Re: Project Approval 06_0074 Modification Request No. 4 – Boral Peppertree Quarry - Marulan

The EPA has reviewed the Environmental Assessment (EA) titled '*Peppertree Quarry Modification 4 – Environmental Assessment*', prepared by Element Environment, dated April 2016. The EPA has identified a number of issues in relation to the modification proposal for the Department of Planning and Environment's consideration in its decision whether not to approve the modification.

Figure 9: Catchment locations on the site of the proposed emplacement area

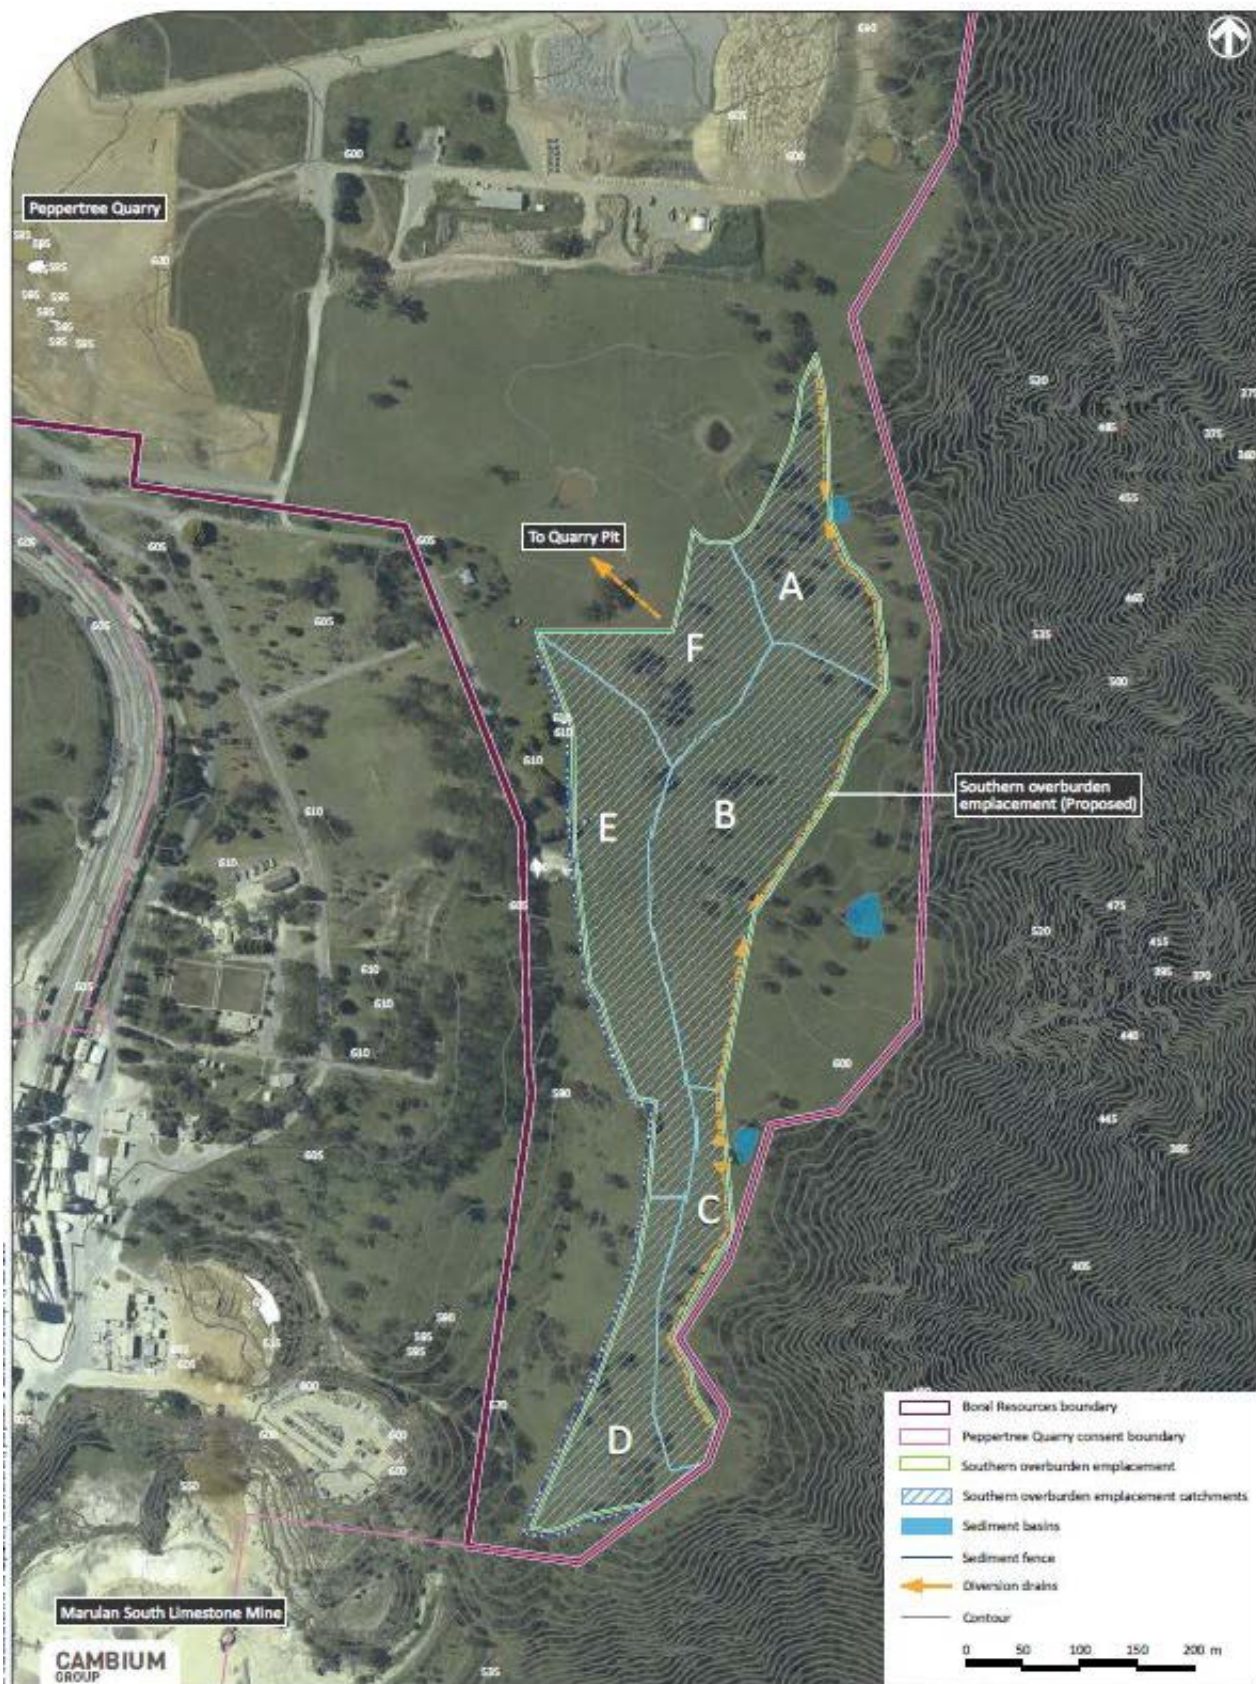
Given the layout and topography of the area, the EPA is concerned that runoff from the south end of proposed new southern overburden emplacement area (Catchment D) may not flow into the North Pit of the Limestone Mine as stated in the SWA. Drainage plans for the proposed southern overburden emplacement are provided in Figure 4.1 of the SWA and it is noted that a drainage line runs along the south east of the proposed

emplacement, but does not continue further along the far southern end of the emplacement area (Catchment D).

The EPA suggests that instead of (or in addition to) the proposed sediment fences along the southern end of the proposed emplacement area, the proposed catch drain along the south-east of the stockpile should be extended along the southern tip of Catchment D. This proposed catch drain could either flow to the west to enter the drainage line which flows into the North Pit of the Limestone Mine, or north-east and north to the proposed sediment basin on the eastern edge of Catchment C. This should guard against sediment washing into the neighbouring sensitive environment.
